From: Charlotte Watkins <Charlotte.Watkins@Cherwell-DC.gov.uk>
Sent: Wednesday, May 24, 2023 2:25 PM
To: Andrew Thompson <Andrew.Thompson@Cherwell-DC.gov.uk>
Subject: 22/01611/OUT

22/01611/OUT
Stratfield Farm OX5 1DL

With regard to the above outline application, I have the following comments:

Reptile Transect Plan

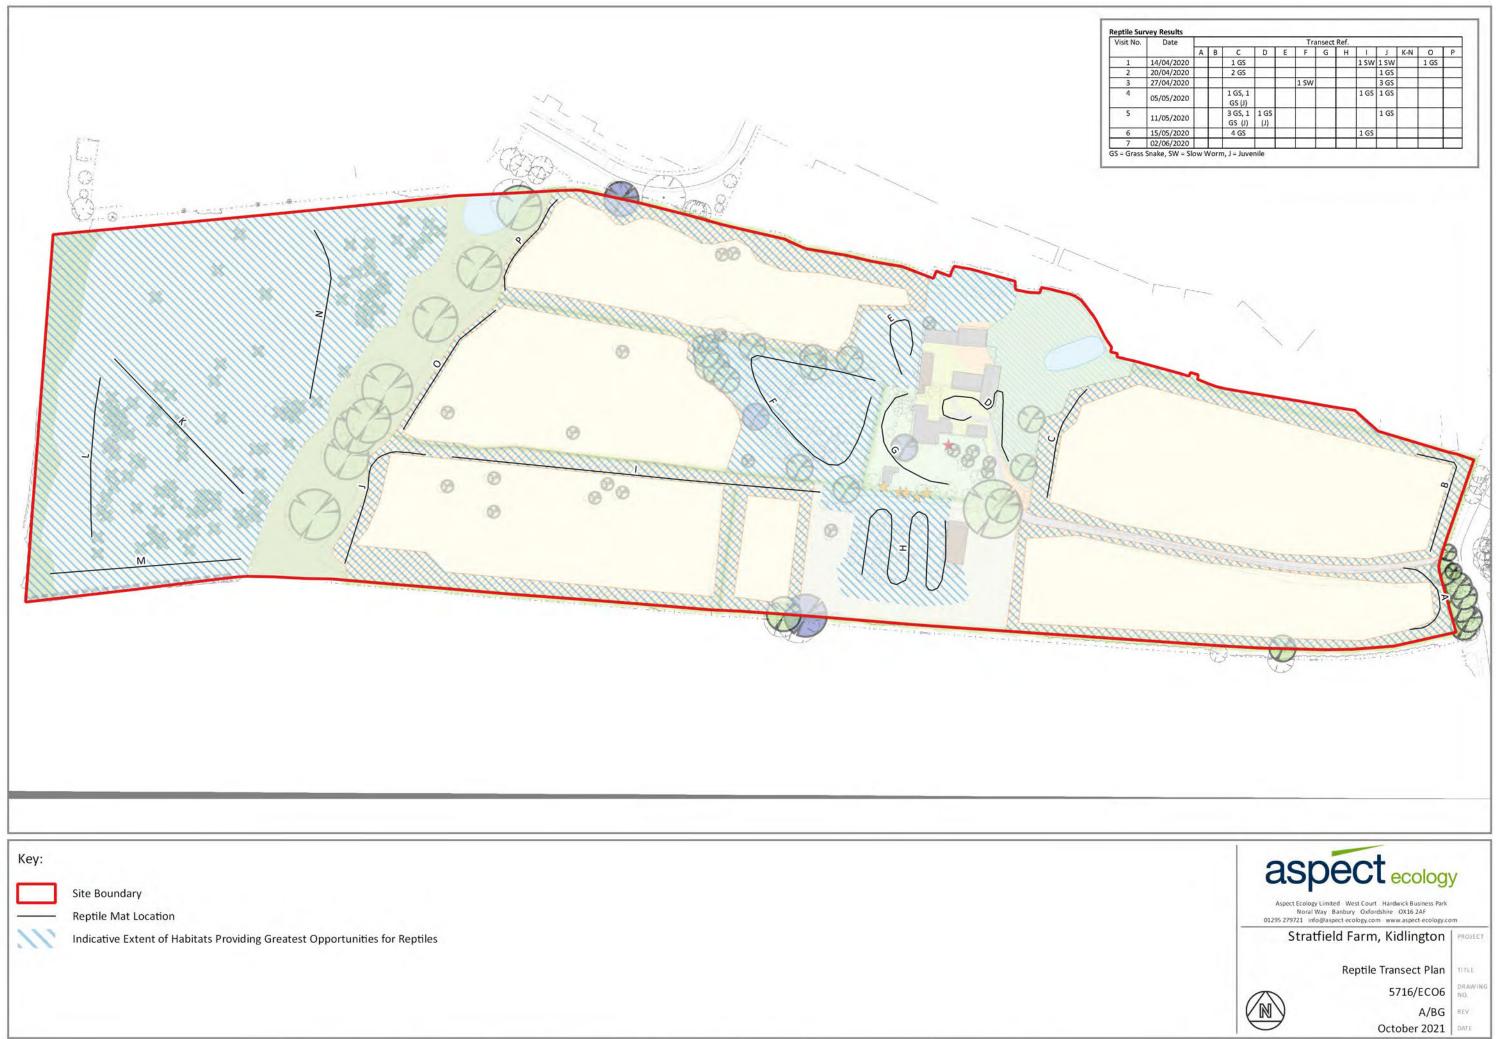
There is a confirmed reptile population on site. Translocation of some of the reptiles on site may be required. A full reptile mitigation strategy should be considered. Receptor sites/areas for reptiles which need to be translocated during construction may require enhancement prior to works commencing.
